**WELWYN HATFIELD BOROUGH COUNCIL  
EXECUTIVE DIRECTOR - PLANNING, PUBLIC PROTECTION AND GOVERNANCE**

**DELEGATED APPLICATION**

**Application No:** 6/2022/2288/HOUSE  
**Location:** 118 Campion Road Hatfield AL10 9FT  
**Proposal:** Conversion of garage into a habitable space and erection of a single storey rear extension following the demolition of existing conservatory  
**Officer:** Ms Kirsty Shirley

**Recommendation:** Granted

Application : Garage conversion, Internal Alterations & Single Storey Rear Extension	
Client :	SVPK Maddipati
Address:	118 Campion Rd, Hatfield AL10 9FT
Detail:	Proposed Floor Plan
Drawn by: SCALEUPPLANS	Date: 30/10/2022 6:23:37 AM
Scale:- 1:100, 1:50@A3	Dwg No: 3.
<b>S Scale-Up Plans</b>

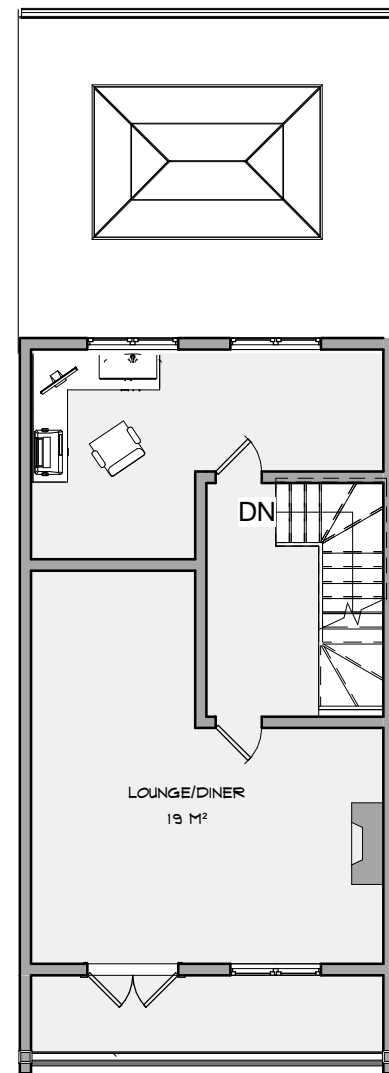
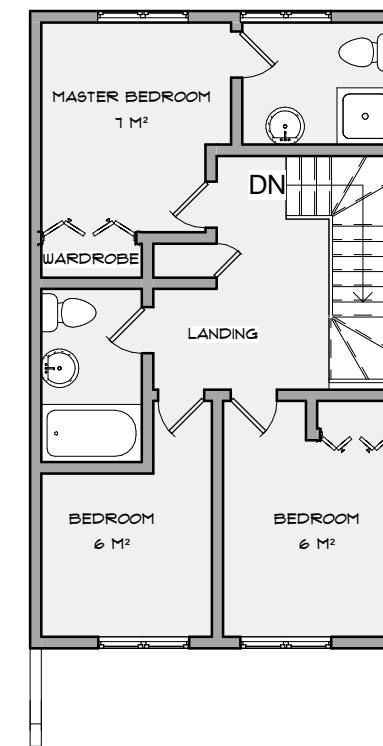
**Comment** (if applicable): The development would not result in an increase in bedrooms within the site and the dwelling would remain as a three-bedroom dwelling. The development would however result in the loss of the garage.

Council's Hatfield Aerodrome SPG 1999 applies to this site and requires two car parking spaces for a 2-3 bedroom dwelling. The Council's Interim Policy for Car Parking Standards and Garage Sizes seeks to ensure new garages have a genuine ability to be used for their intended purpose and will require them to be at least 6 metres long by 3 metres wide and sufficiently tall to accommodate modern cars.

The garage within the application site measures approximately 5.3m in length and approximately 2.5m in width. While the garage dimensions fall below the identified size requirements, the size of the garage could reasonably park a vehicle. The loss of the garage would result in the loss of a car parking space. However, the submitted plans and photographs with this application demonstrate two vehicle car parking spaces to the front of the site. The development would therefore retain sufficient on-site car parking.
